An  
Bord  
Pleanála

**Board Direction**  
**BD-008666-21**  
**ABP-309703-21**

Ex VMRA drawing 18614-VCR-ZZ-B1-DR-M-200 Rev C03.01

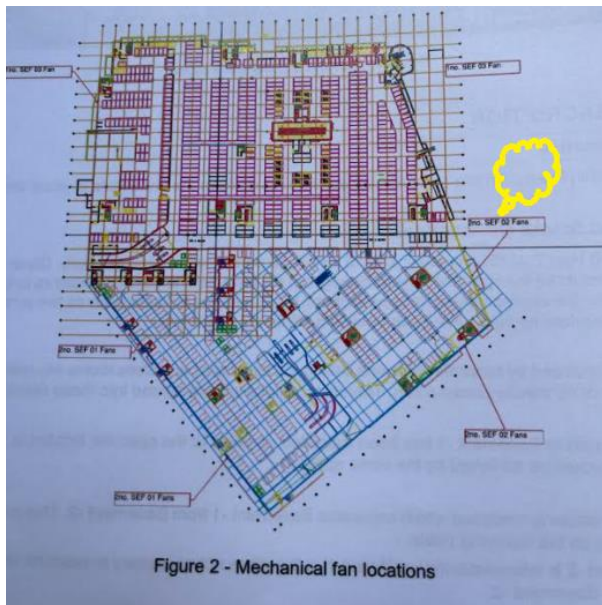
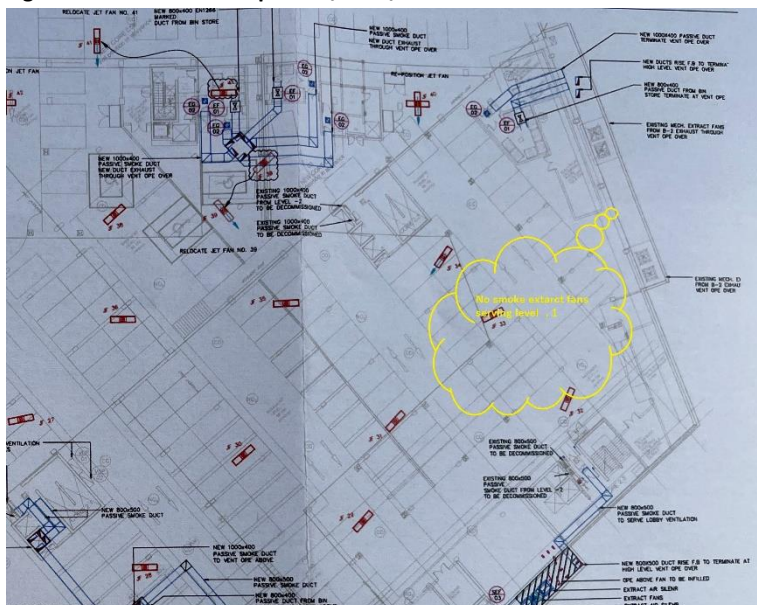
2. The ventilation system for the car park at Levels -1 and -2 shall comply with paragraphs 3.5.2.4 or 3.5.2.5 of Technical Guidance Document B 2006 or Clause 9 of BS7346 - Part 7, 2013 *Components for smoke and heat control systems – Part 7: Code of practice on functional recommendations and calculation methods for smoke and heat control systems for covered car parks*. Revised details of the ventilation system demonstrating compliance with this requirement shall be submitted to, and agreed in writing with, the Building Control Authority, prior to the making available of blocks U, T and W for occupation and prior to the continuation of use of the basement car park following commencement of development.
